CITY OF ALBUQUERQUE

February 8, 2016

**Re: Catholic Charities
2010 Bridge Blvd., SW
Traffic Circulation Layout**
Engineer's/Architect's Stamp dated 2-2-16 (L12-D012)

A1 TRAFFIC CIRCULATION LAYOUT AND SITE DIMENSION PLAN

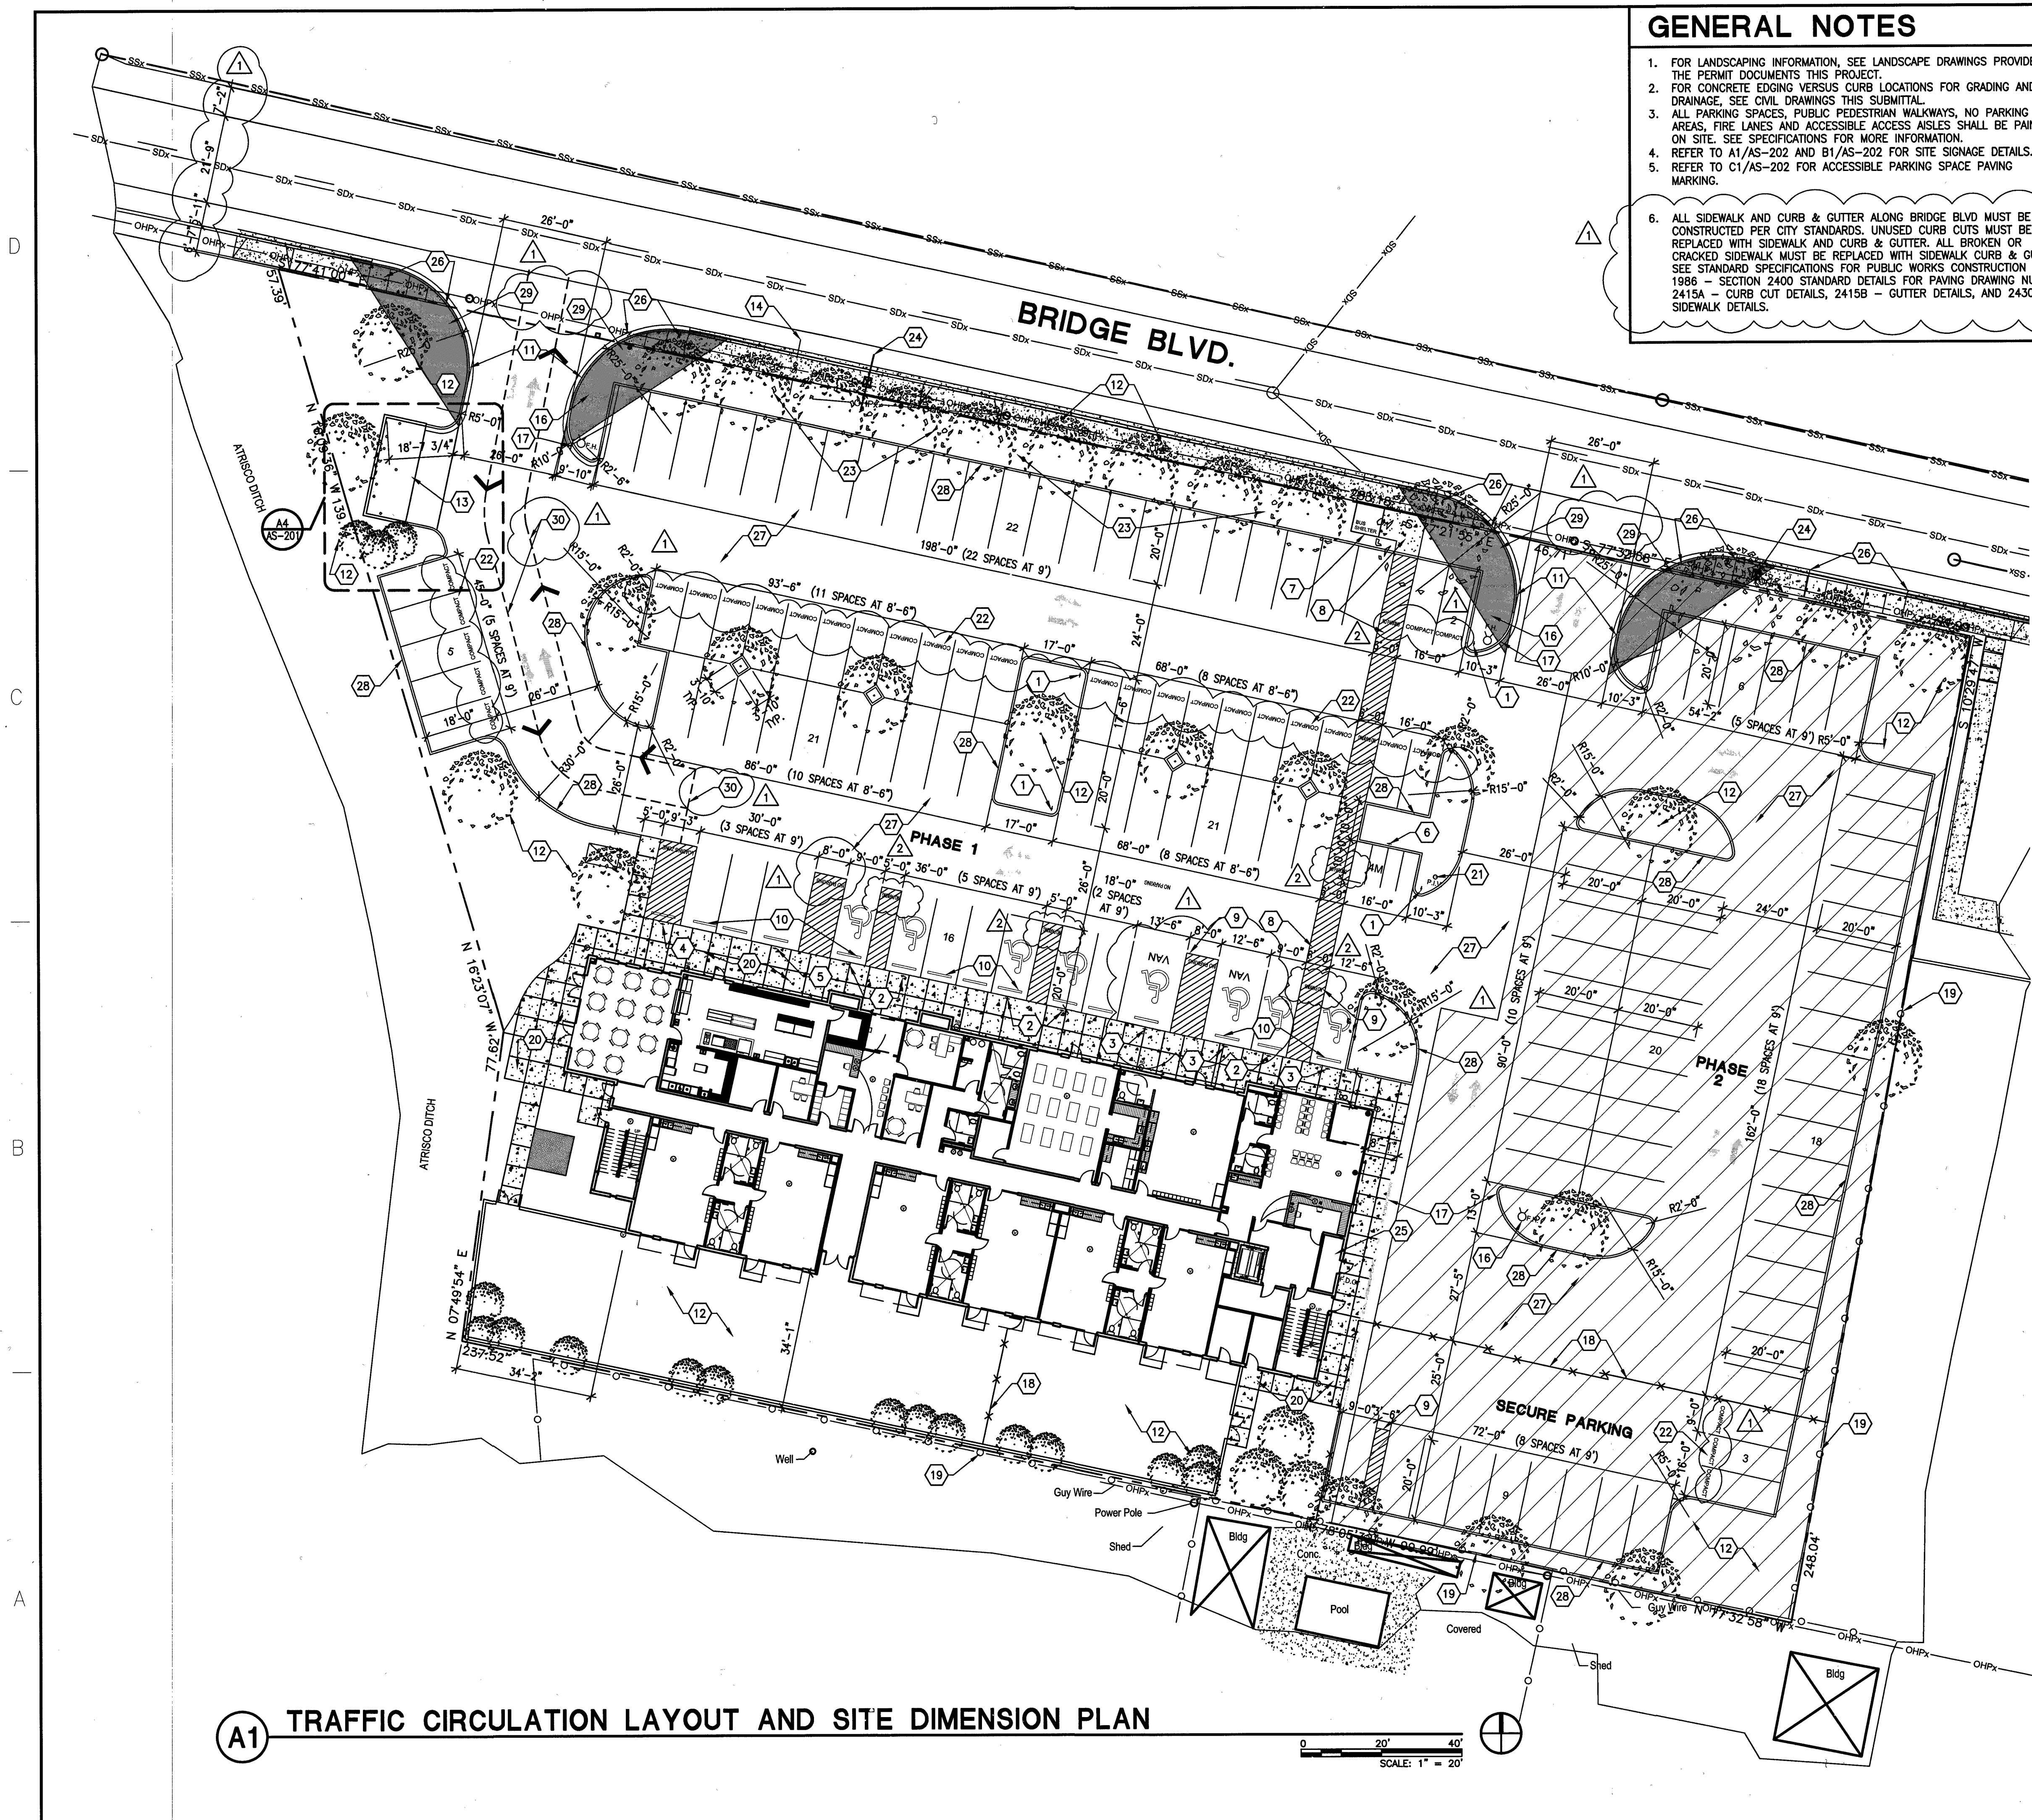
1. The van wheelchair accessible spaces must include an 8-foot wide access aisle; all other aisles should be 5 feet in width. This is in accordance with the federal Americans with Disabilities Act - Accessibility Guidelines, which supersedes COA Codes. The federal guidelines are being incorporated into the Development Process Manual (DPM).
2. All ADA access aisles shall have the words "**NO PARKING**" in capital letters, each of which shall be at least one foot high and at least two inches wide, placed at the rear of the parking space so as to be close to where an adjacent vehicle's rear tire would be placed. (66-1-4.1.B NMSA 1978)
3. Please include two copies of the traffic circulation layout at the next submittal.
